2, Elmer Court,  
Elmer Sands,  
PO22 6JT

16 January 2026

The following is an objection to certain parts of the planning permission **M/98/25/HH** which follows enforcement case **ENF/328/24** following refusal and dismissed appeal of **M/100/24/HH**

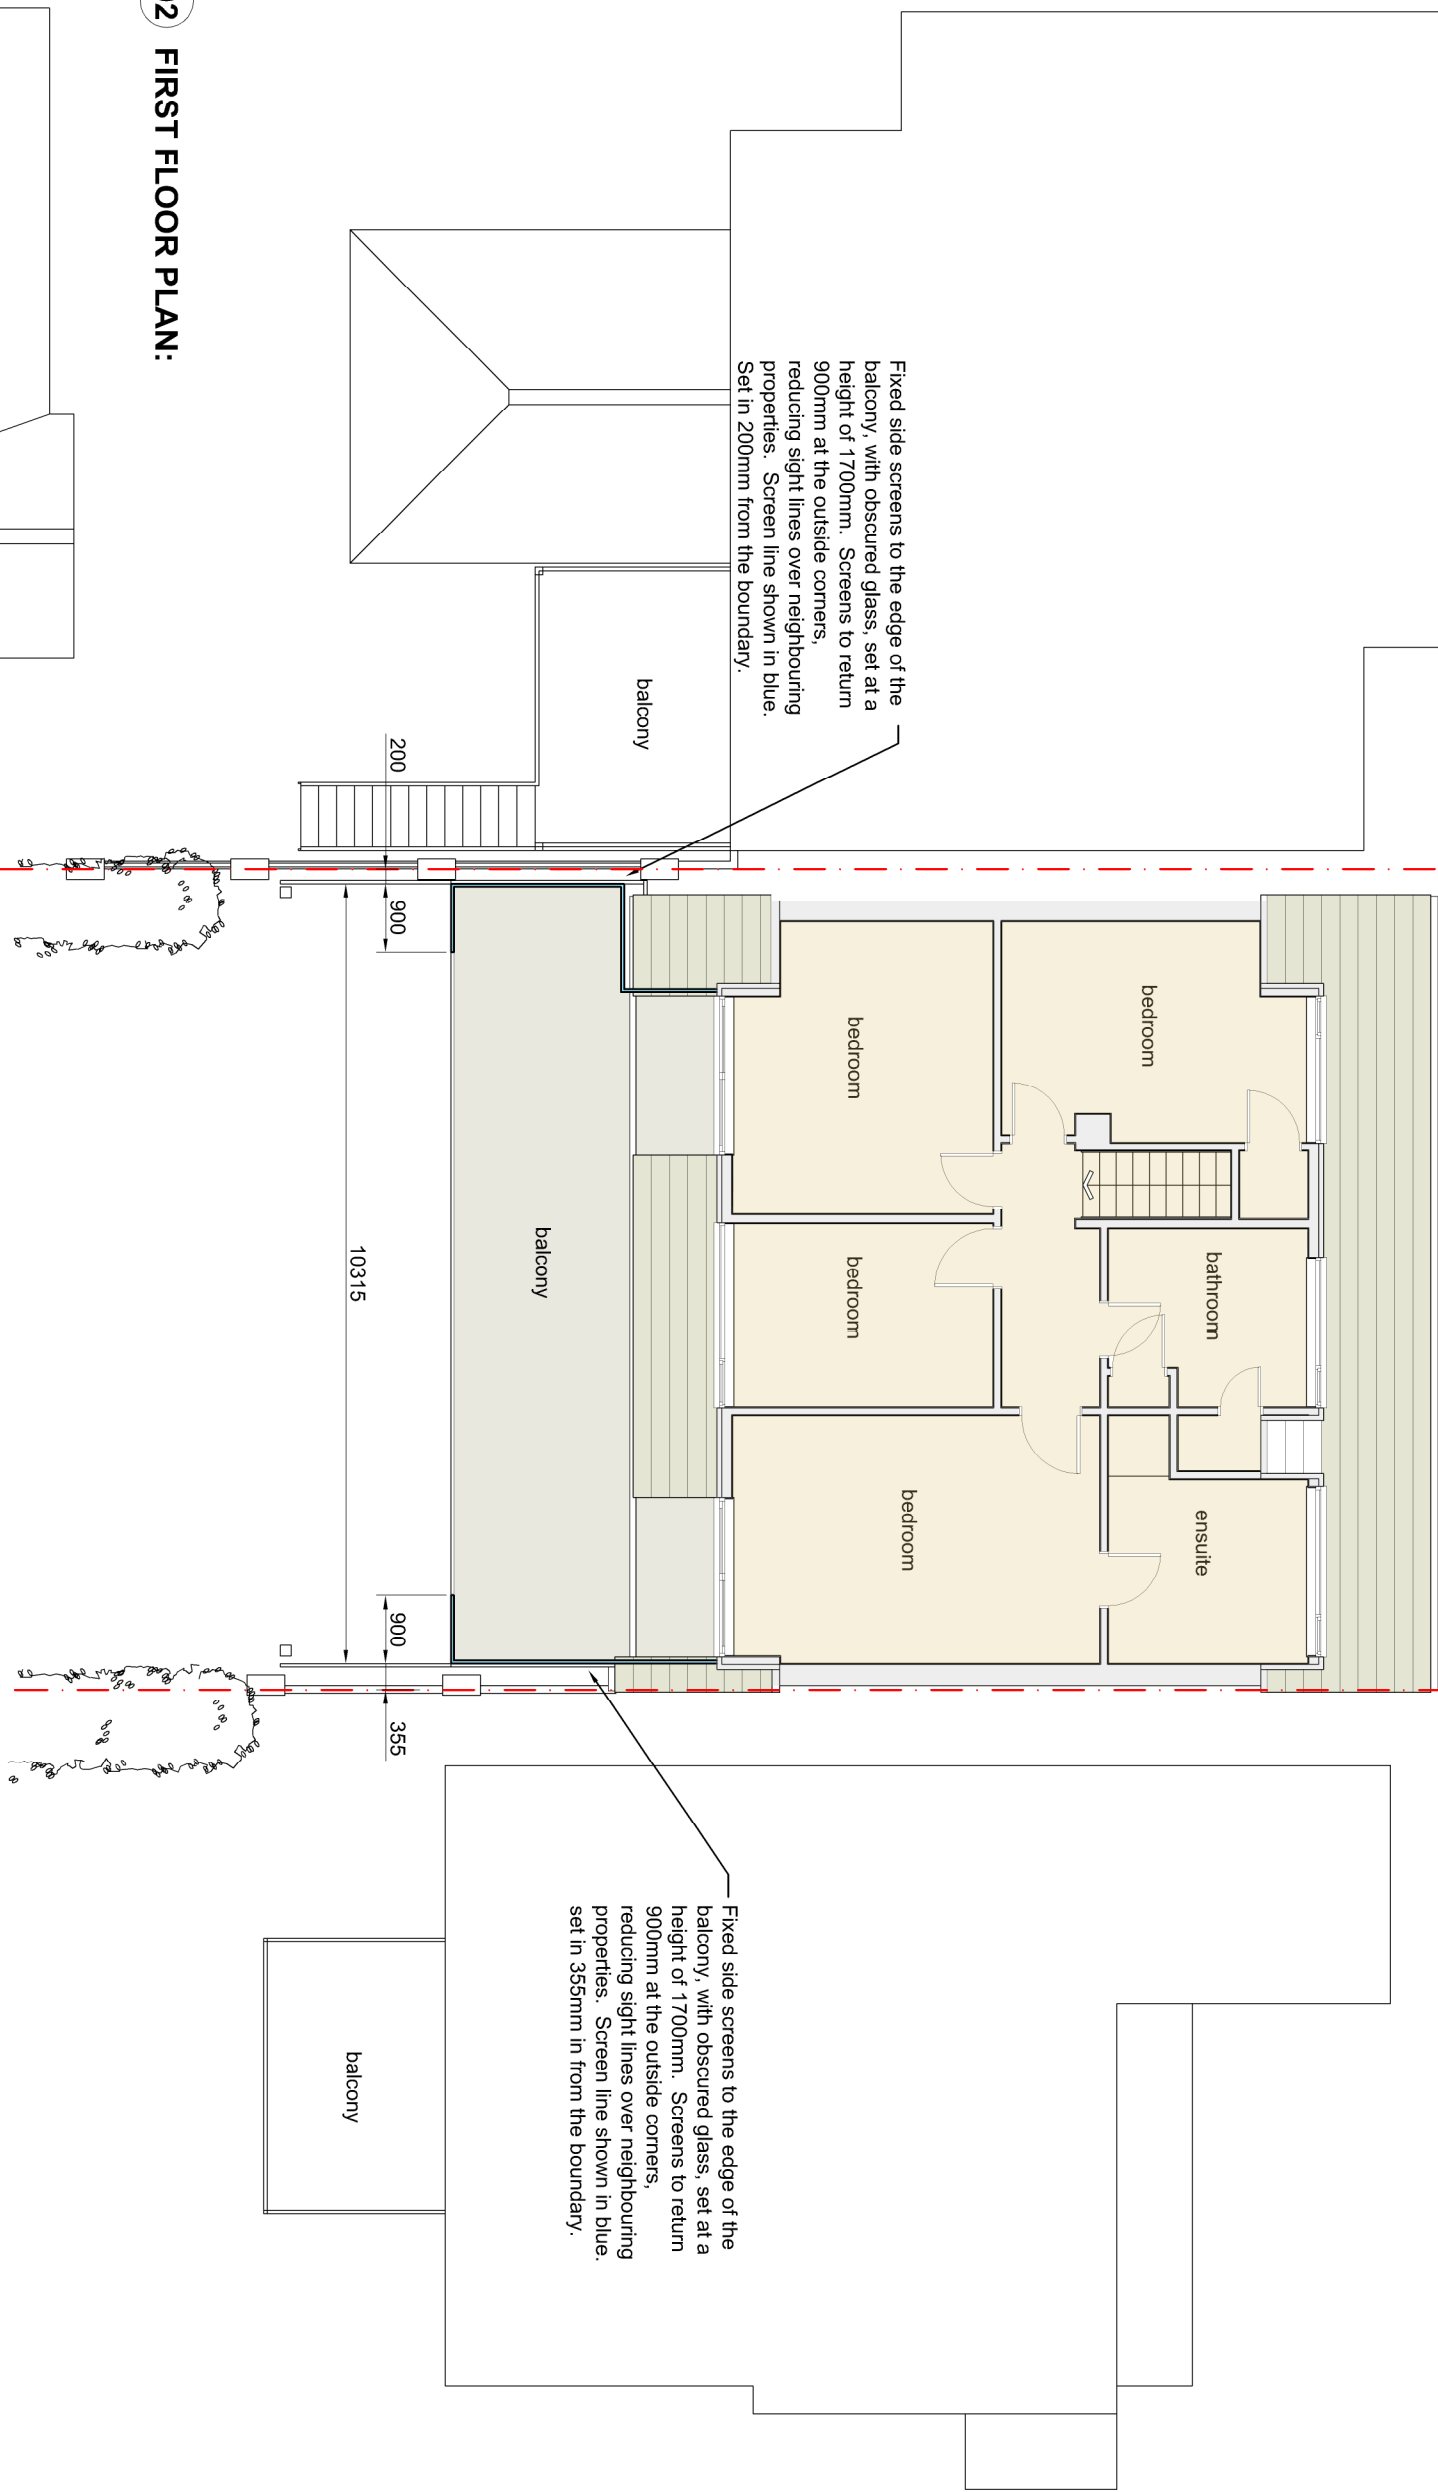
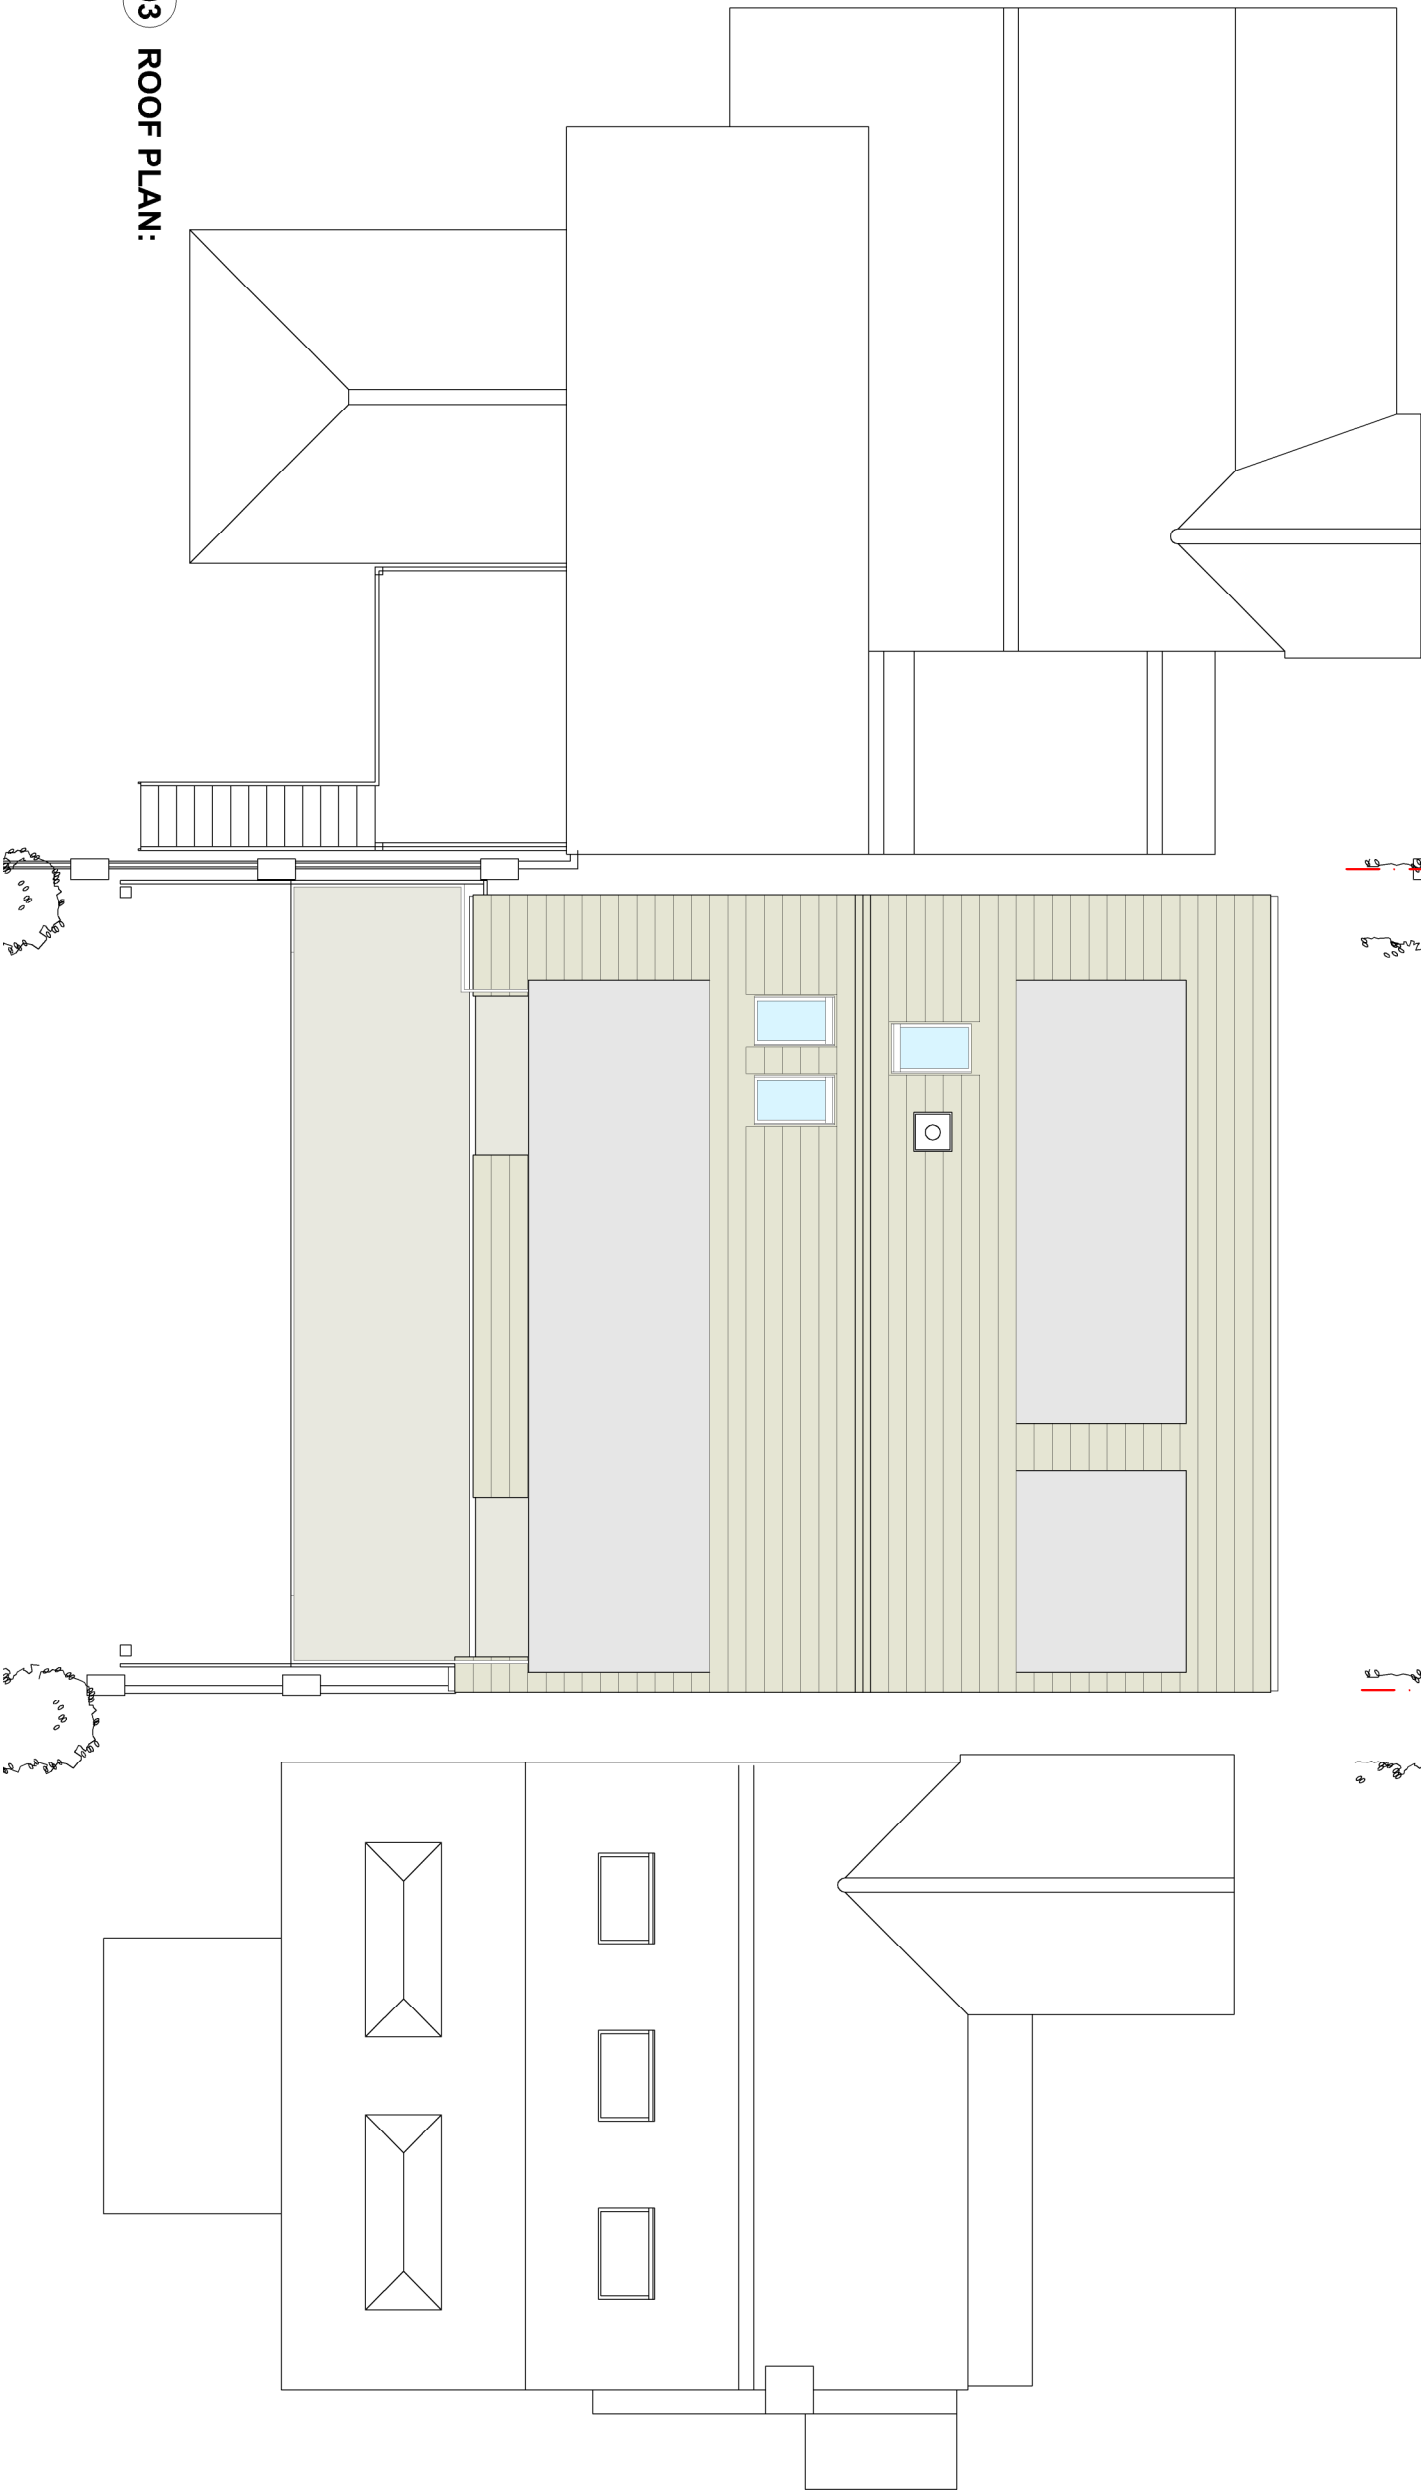
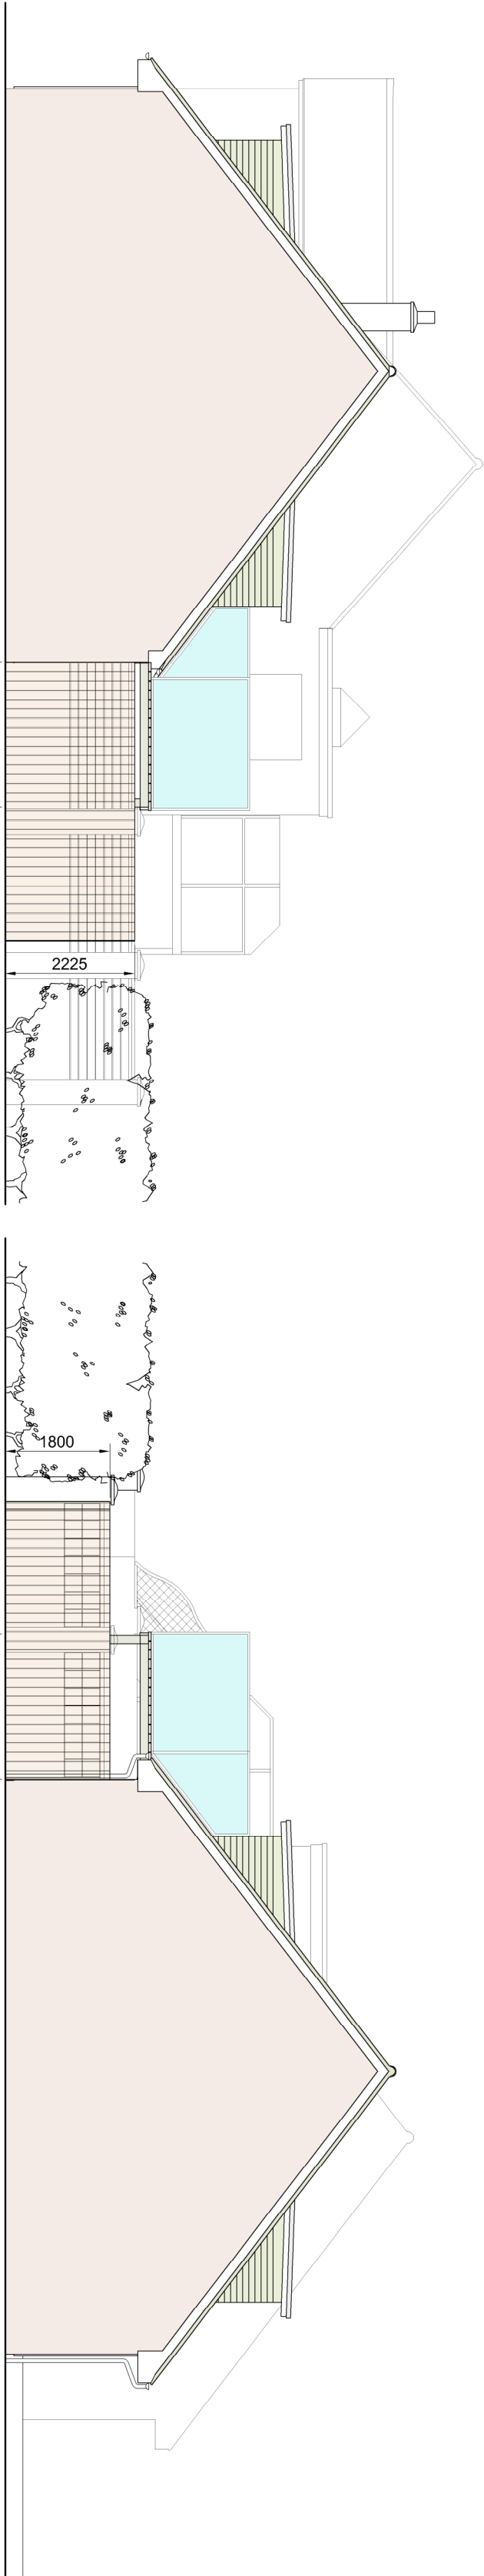
- In the Proposed Plans and Elevations between No.1 and No.2 Elmer Court, the measurement given from the edge of the balcony platform to the actual boundary line (which runs along the centre of the party boundary wall) is actually 250mm not 355mm as shown. The distance from the edge of the balcony platform to the edge of the boundary wall is just 180mm which actually answers the question asked by Arun in their letter of 24<sup>th</sup> December 2025, “*Site Plan - Please add the dimensions from the proposed balcony extension to each site boundary edge*”. These measurements **are actual** as they have been physically taken from the already built unlawful structure to the boundary line/party wall.

In this case the gaps between No.4 The Hard, 1, Elmer Court and 2, Elmer Court are indeed “relatively small”, and is very small at 98cm between No.1 and No.2 and as the balcony is at first floor level it fails the test, “*any extension or alteration at first floor level does not come to within a minimum of one metre of the side boundary*”. The balcony edge is currently just 25cm from the boundary line between 1 and 2 Elmer Court and 18cm from the edge of the boundary wall.

In addition the height, including the substantial metal and opaque glass side screens built on the balcony platform which itself will be on top of a solid wood fence will be 4.50 meters tall built right up to the boundary maintaining the overshadowing and overbearing aspect and sense of enclosure as identified by the Arun Planning officer in their refusal and also identified by the planning Inspector when dismissing the appeal.
